From: Bloomer, David <David.Bloomer@lancashire.gov.uk>
Sent: 17 May 2018 10:15
To: Stephen Kilmartin
Cc: LHS Customer Service; planning
Subject: app3/2018/0181 Land off Waddington Road, Clitheroe

There are a number of issues with the proposed layout particularly in respect of the parking provision for the development . I am concerned that a number of the properties have substandard parking provision both on the drives and the dimensions of the proposed garages which could lead to vehicles overhanging and obstructing the footway. Parking should be provided at the following levels commensurate with the size (number of bedrooms per property)

Figure 27 - Proposed Car Parking Plan

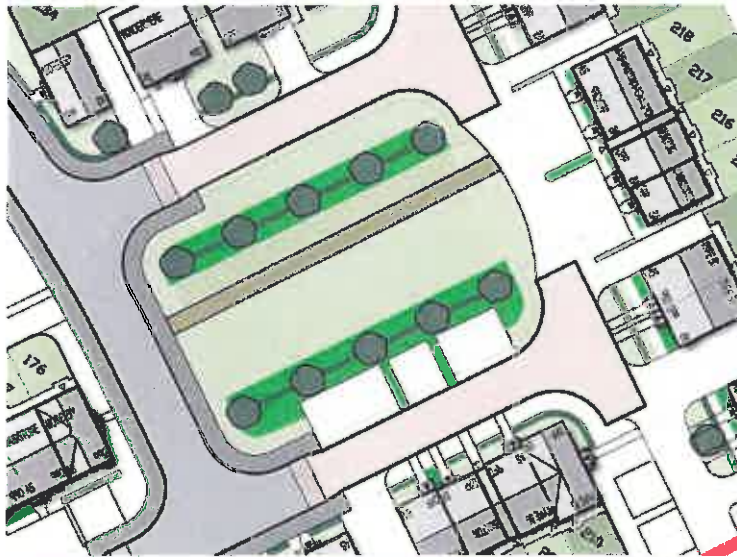
1 bed - 1 parking space
2 to 3 beds - 2 parking spaces
4+ beds – 3 parking spaces.

Spaces provided on drives should be a minimum length of 5.6m rising to 6m when abutting a garage door. Width 2.4m

Garages should be a minimum of 6m x 3m to be regarded as parking spaces

Before I am in a position to raise no objection to the proposal I would need to see amended plans addressing the above concerns
